Application Reference: 6/2021/0474/COND

Proposed development at: 34 Vineyard Road Northaw EN6 4PA

Proposal: Submission of details pursuant to conditions 2 (landscape works) and 3 (biodiversity) on planning permission 6/2020/1365/FULL

date: Jan. 2021 scale: 1:100 @ A1 drg.no: L2006/01 rev: A

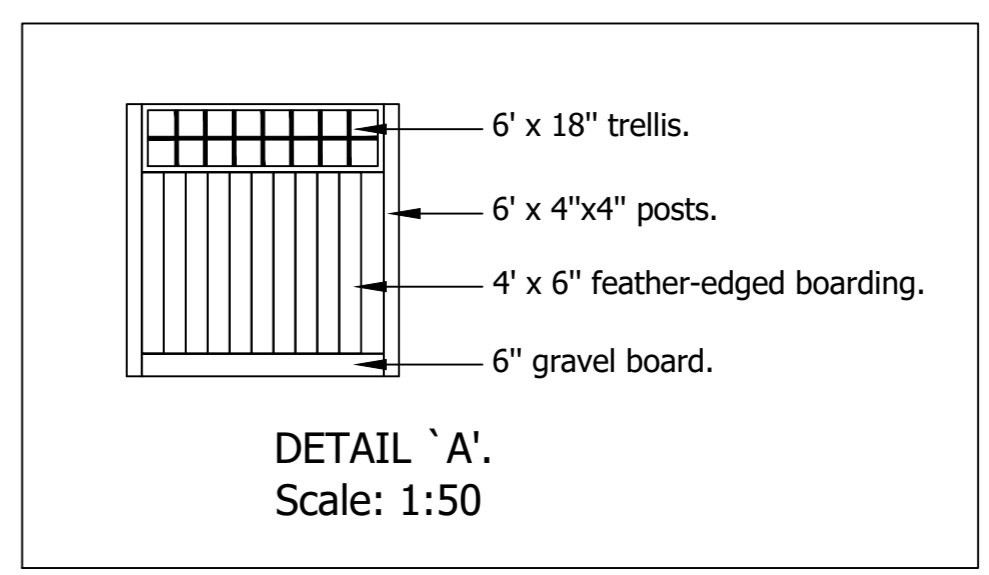
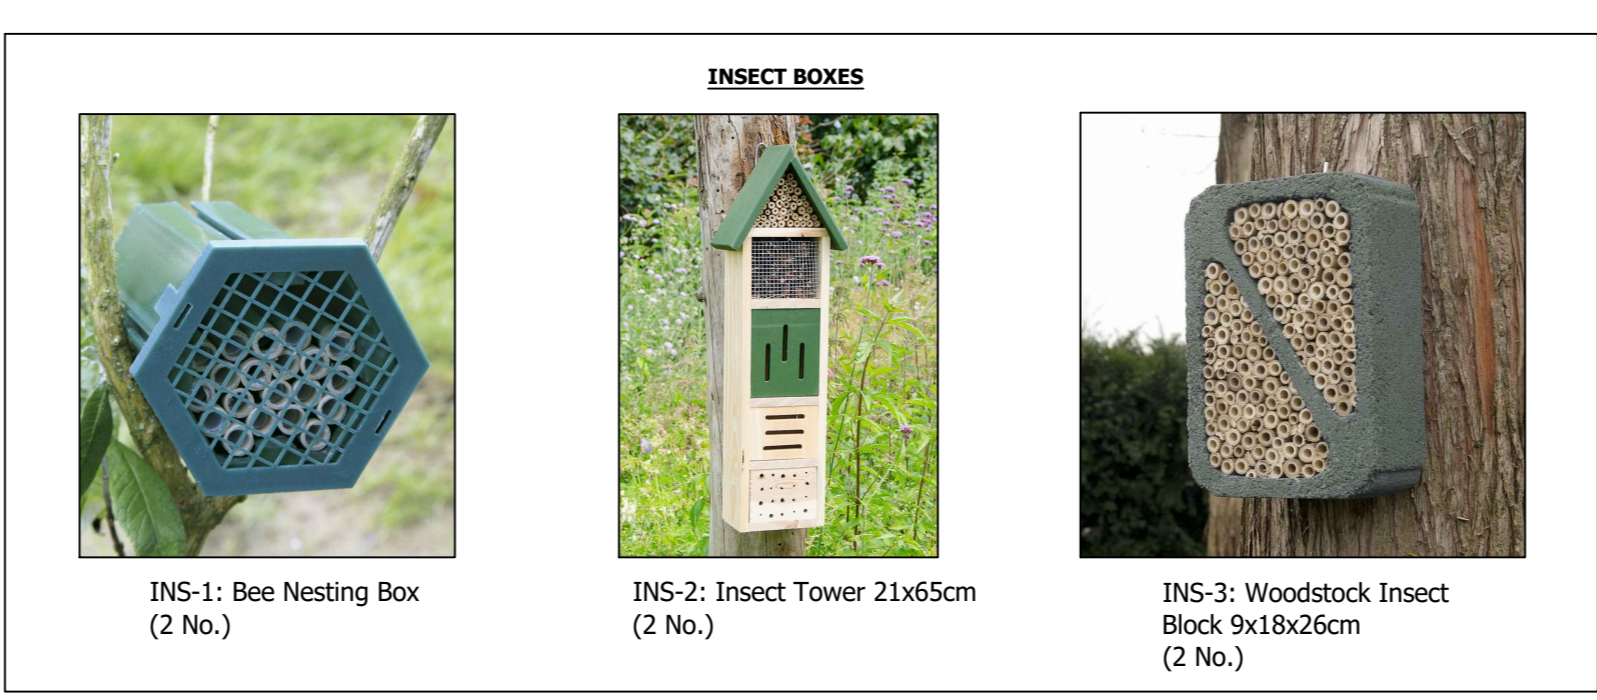
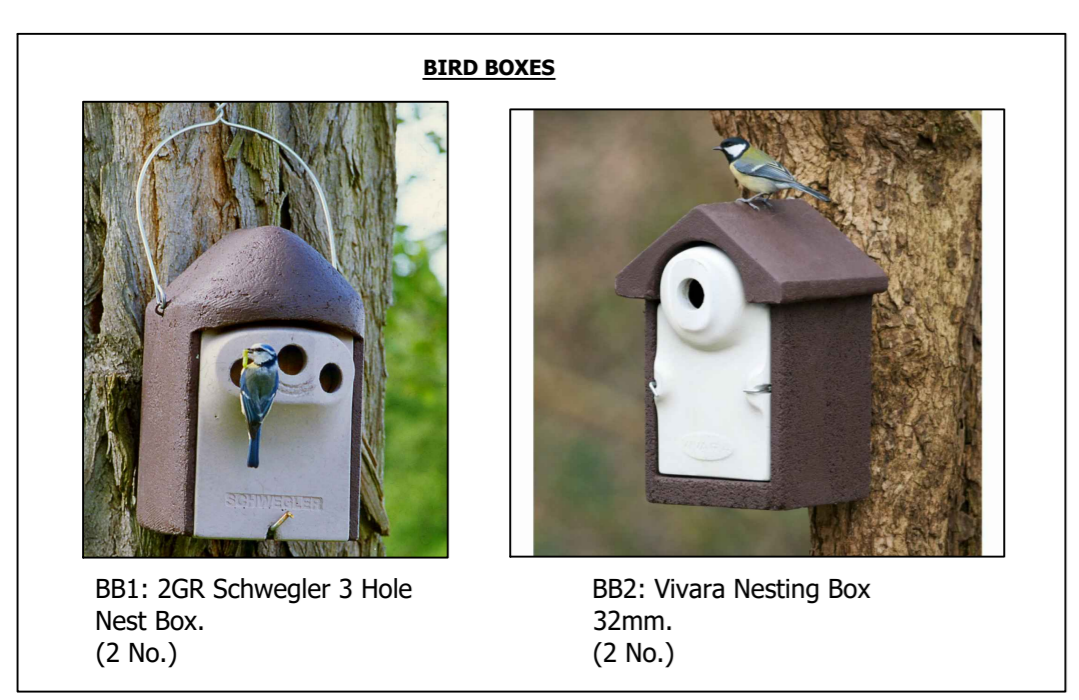
The submitted site plan (drawing number L2006/01 Rev A submitted 19 April 2021) is considered acceptable pursuant to the above requirements.

I can confirm that the details submitted and stated on the proposed site plan (drawing number L2006/01 Rev A submitted 19 April 2021), the photograph titled 'Vincent Bat Box Tree' submitted 19th April 2021 and the link in an email submitted 19th April 2021 to the Vincent Pro Bat Box are acceptable details pursuant to this condition. Please note that the development must be implemented in accordance with these approved details and subsequently, the approved materials shall not be changed.
